Arun District Council
Arun Civic Centre
Maltravers Road
Littlehampton
West Sussex BN17 5LF
Planning & Building Control General Enquiries
Tel: (01903) 737756 Fax: (01903) 730442
Dx: 57406 Littlehampton
Minicom: 01903 732765
e-mail: planning@arun.gov.uk
website: www.arun.gov.uk/planning

Application No: FG/114/21/HH
Site Address: 23 South Drive Ferring BN12 5QU
Description of works: Extensions and internal and external remodelling of existing dwelling to create a 4no. bedroom dwelling with double garage including single storey rear extension, replacement and reformation of roof to create second floor accommodation with rear balcony, associated landscaping.

Thank you for your internet representation made on 8th August 2021 which has been recorded as an objection with the comments as follows:

Drawing Name
**Second Floor Plan and Roof Plan -
Existing**

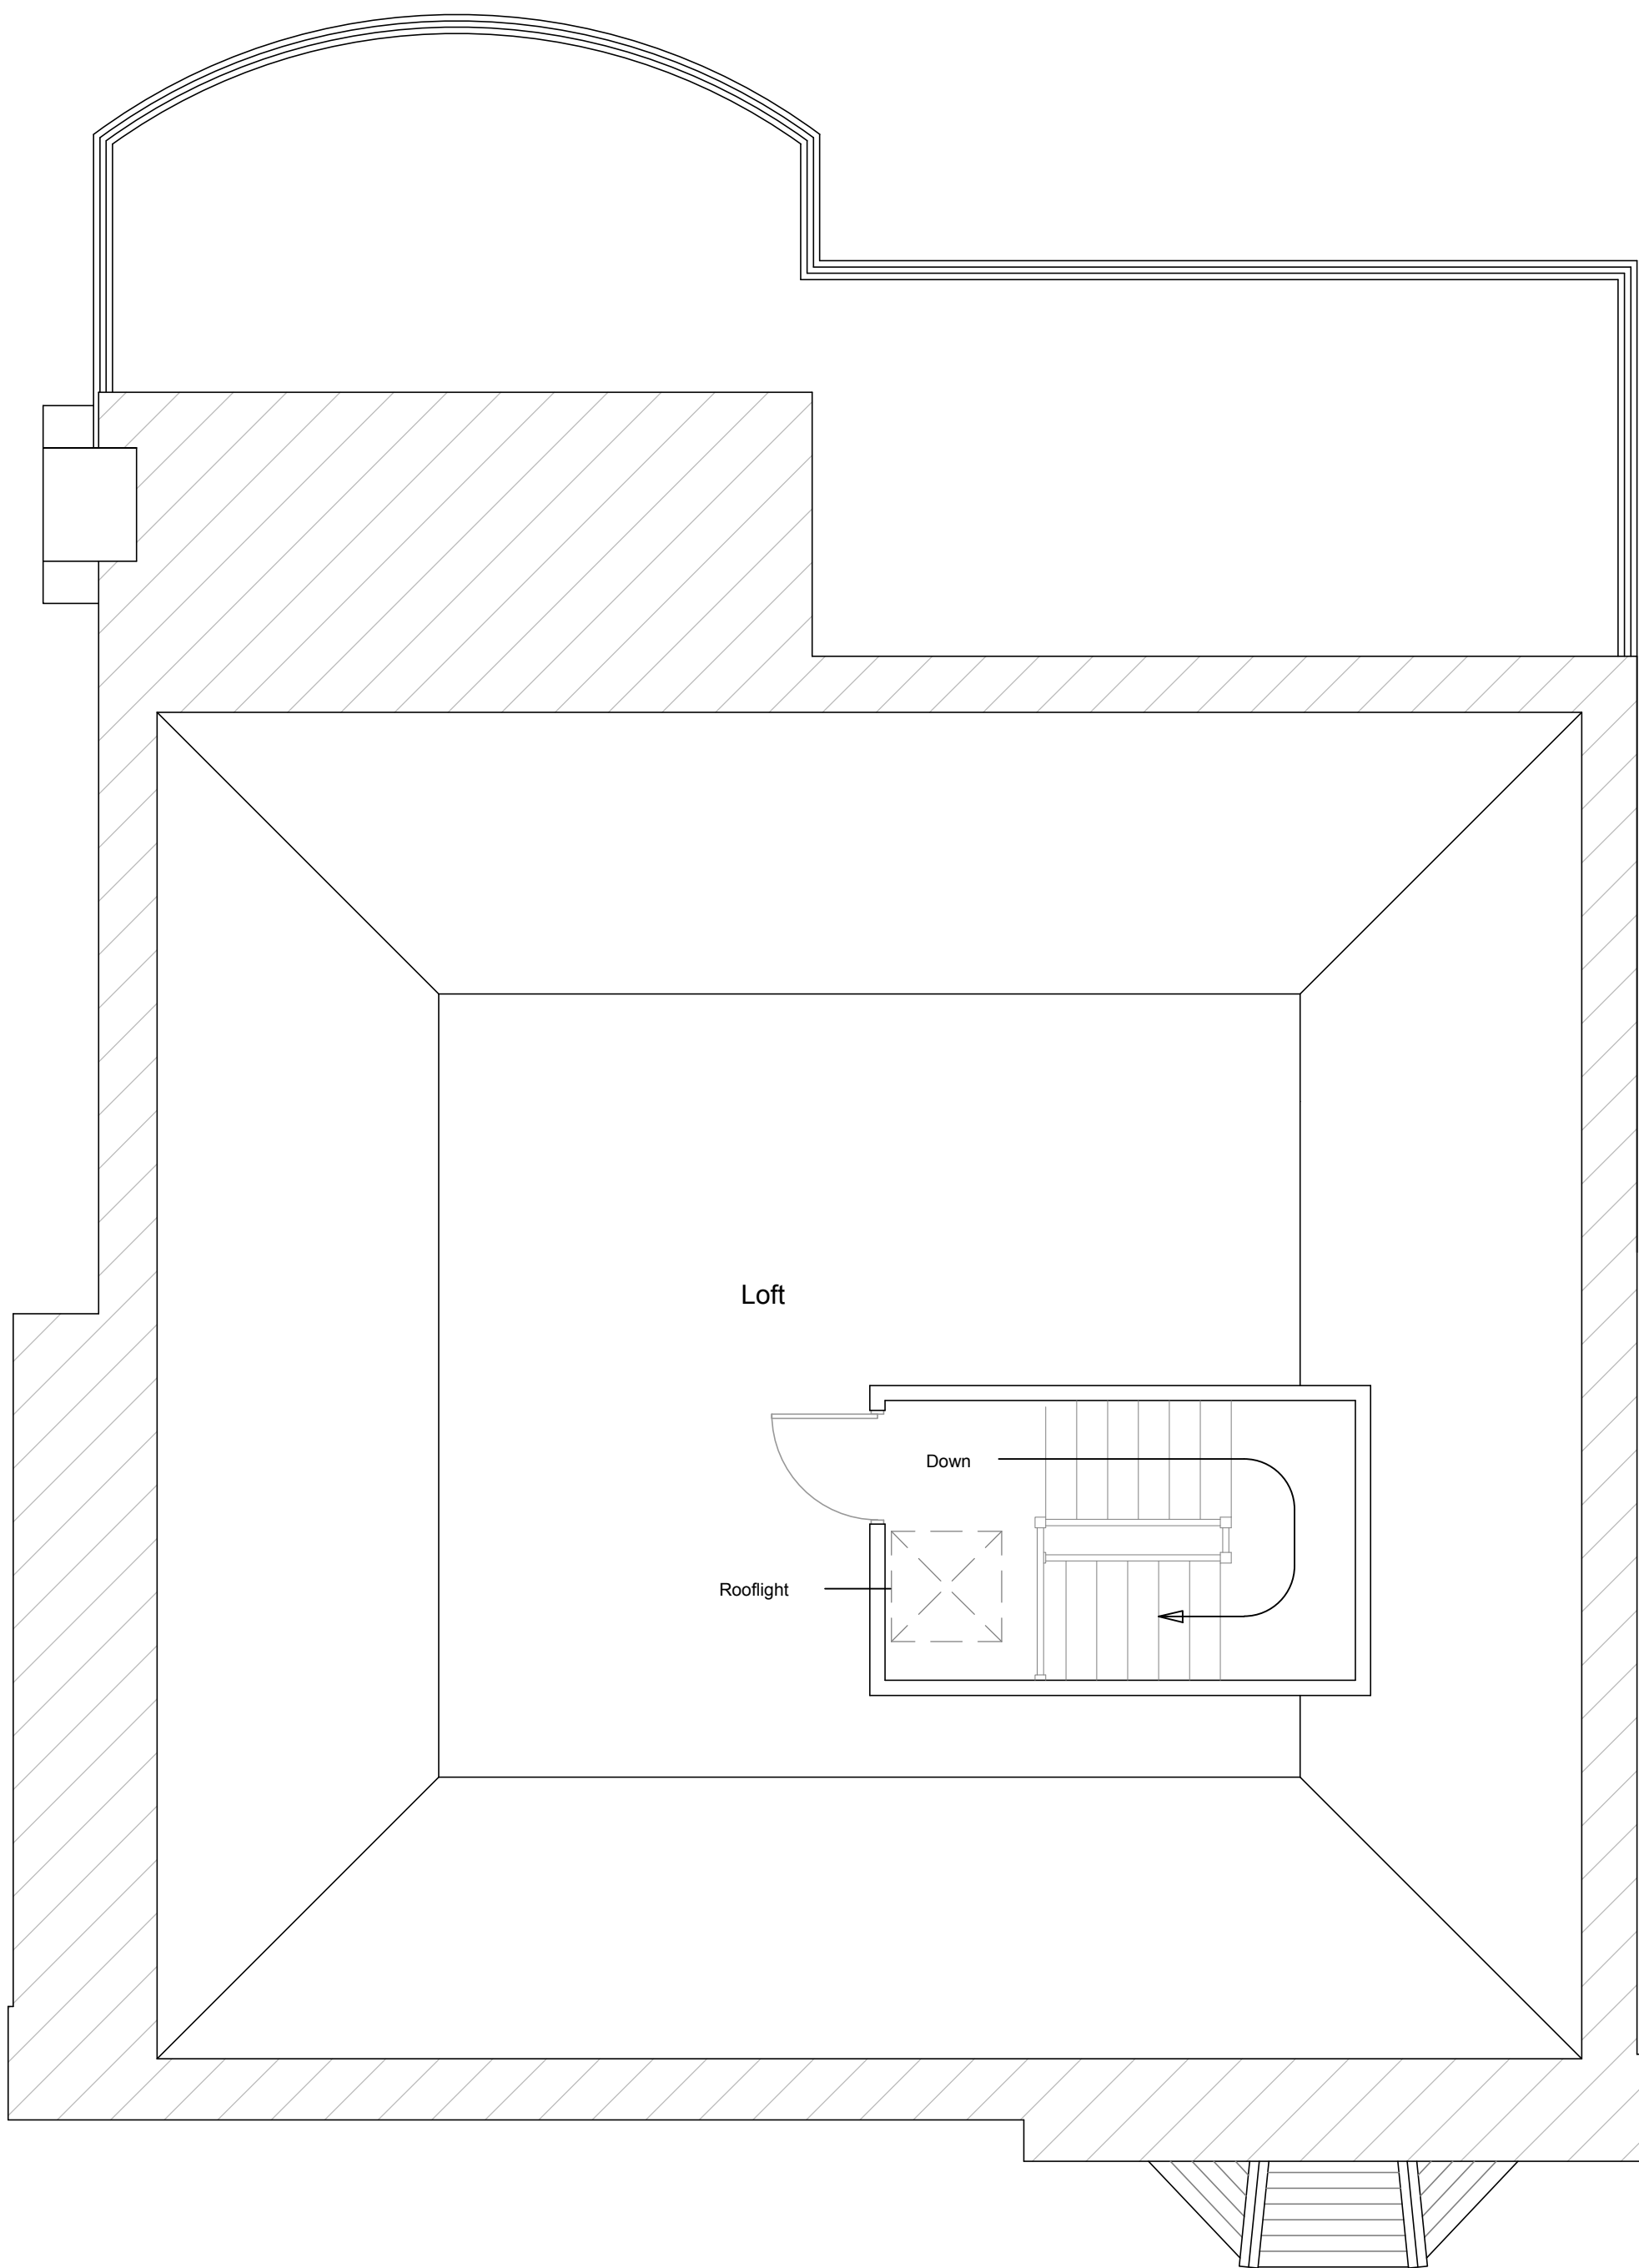
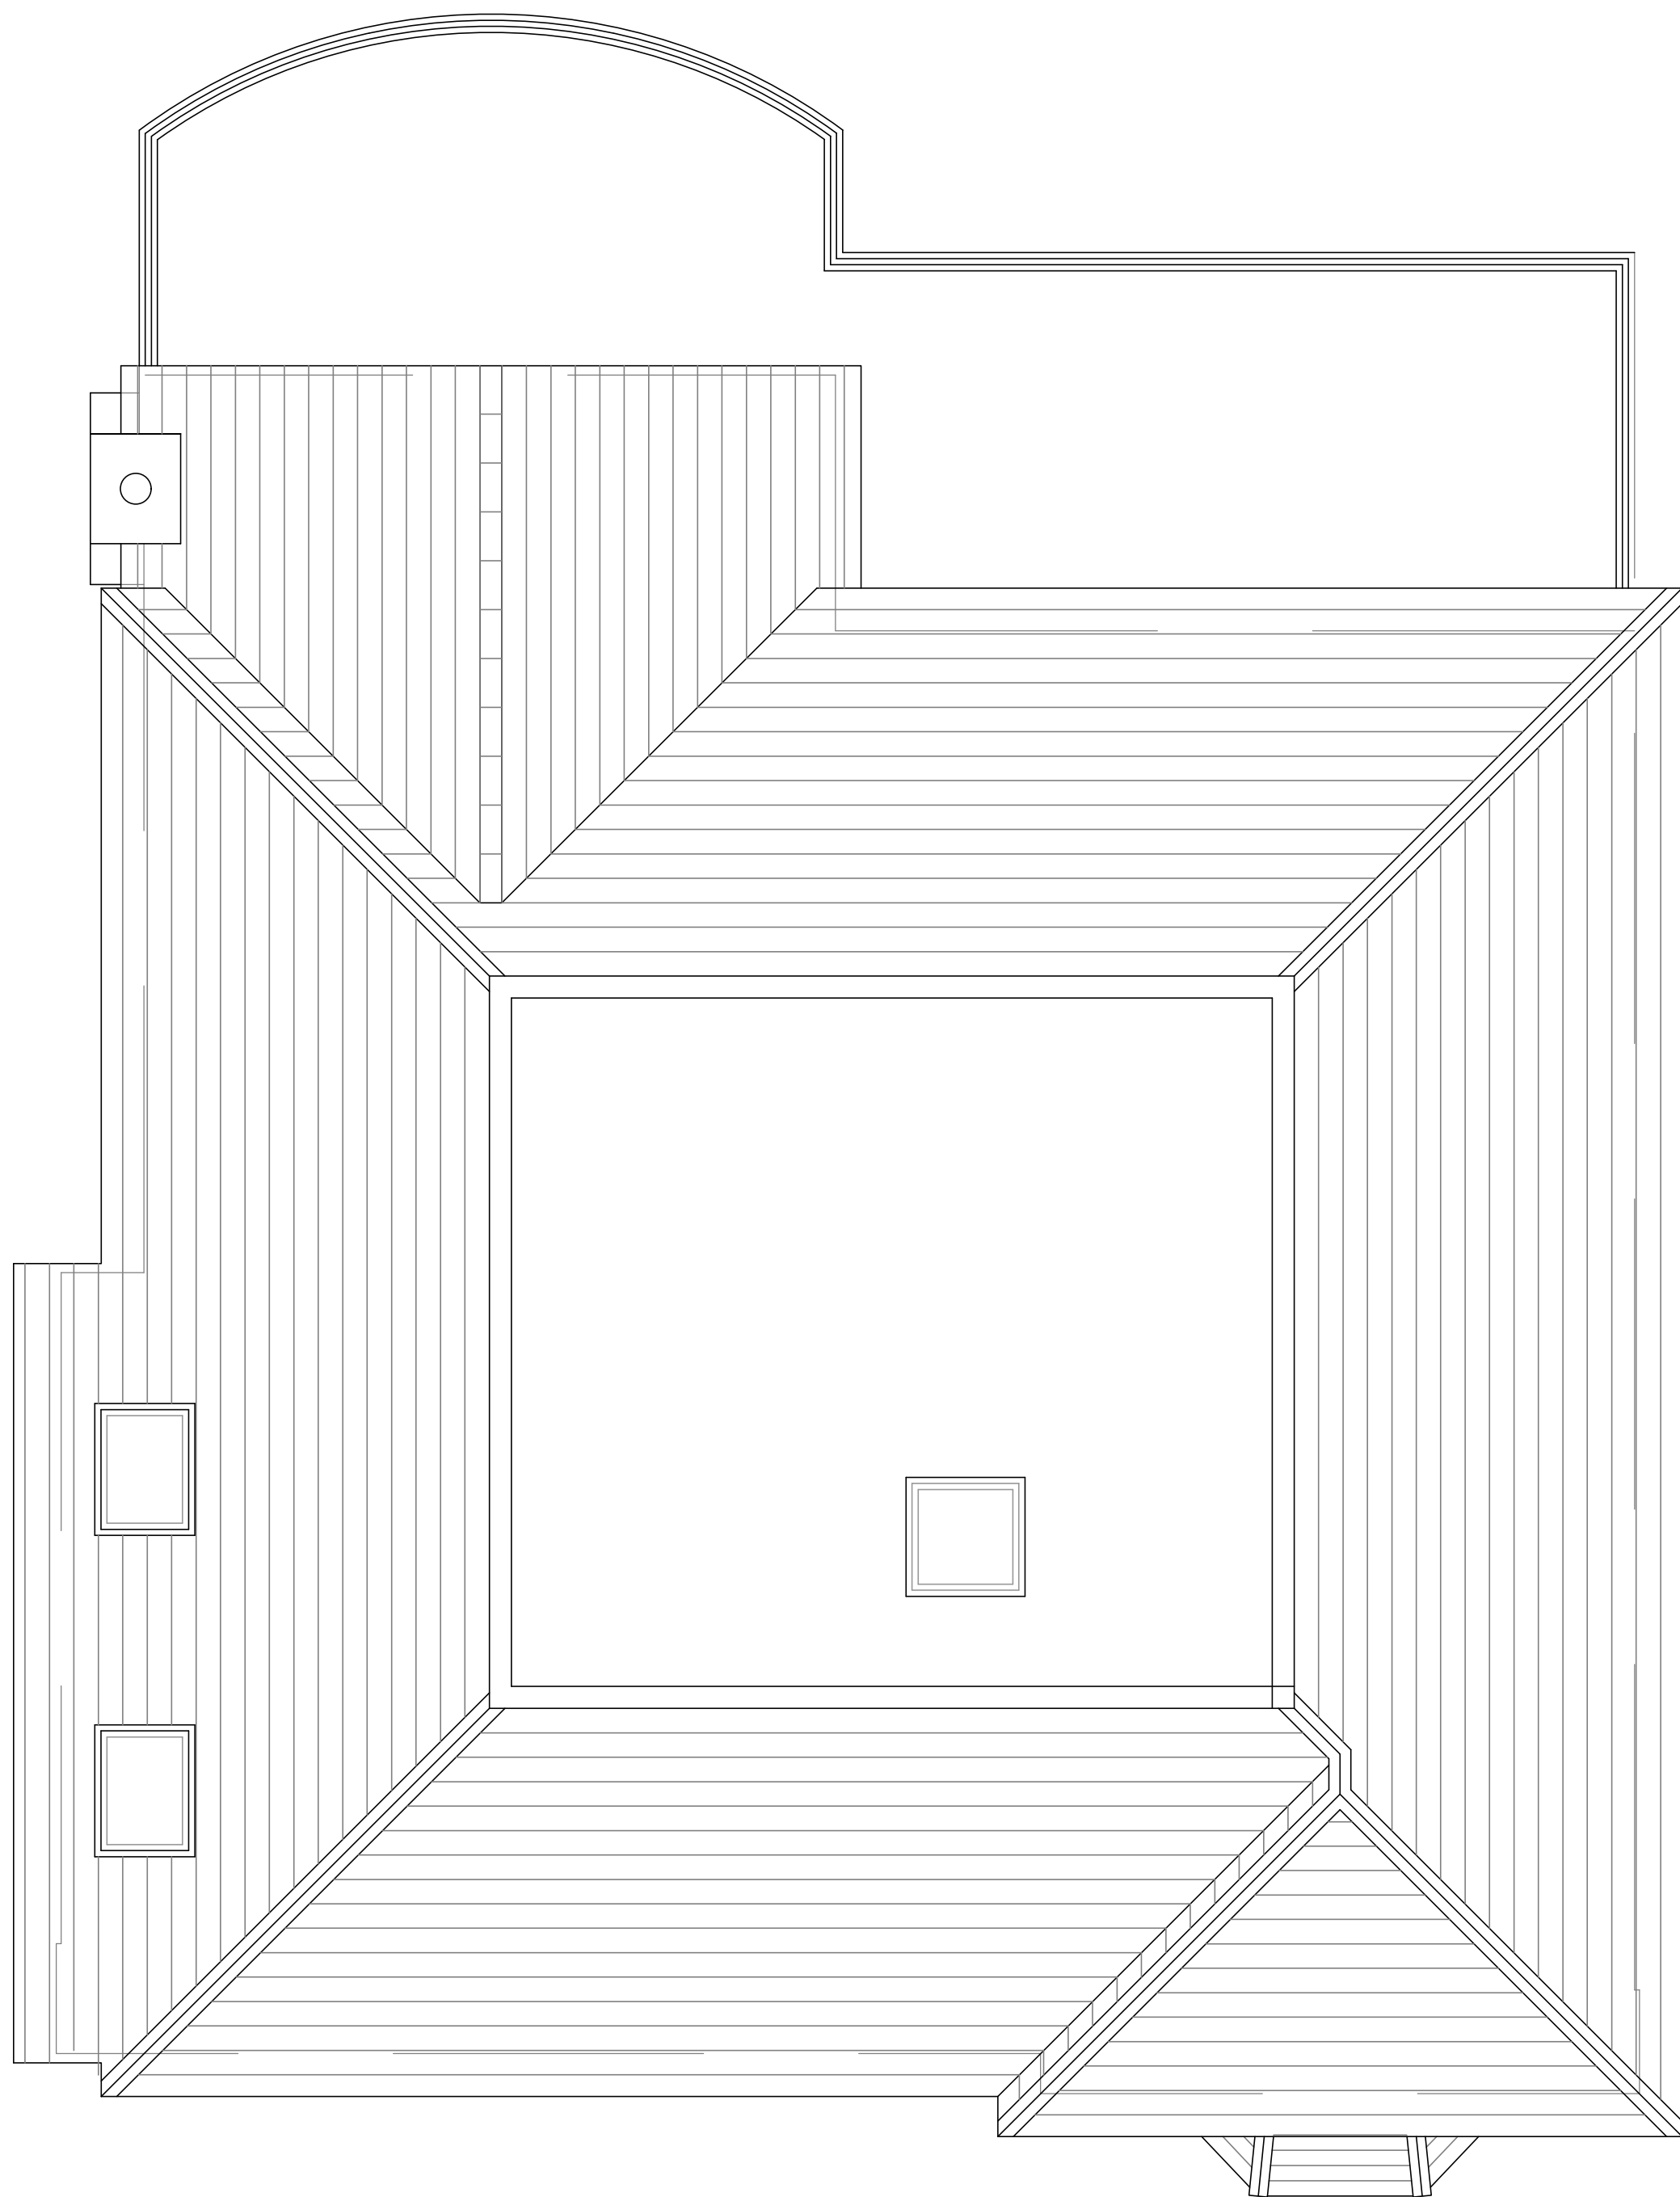
This proposal replaces the whole of the roof structure with a third habitable layer. This third layer will overlook properties to the north and will be overbearing to existing properties to east and west. For these reasons this proposal should be opposed.
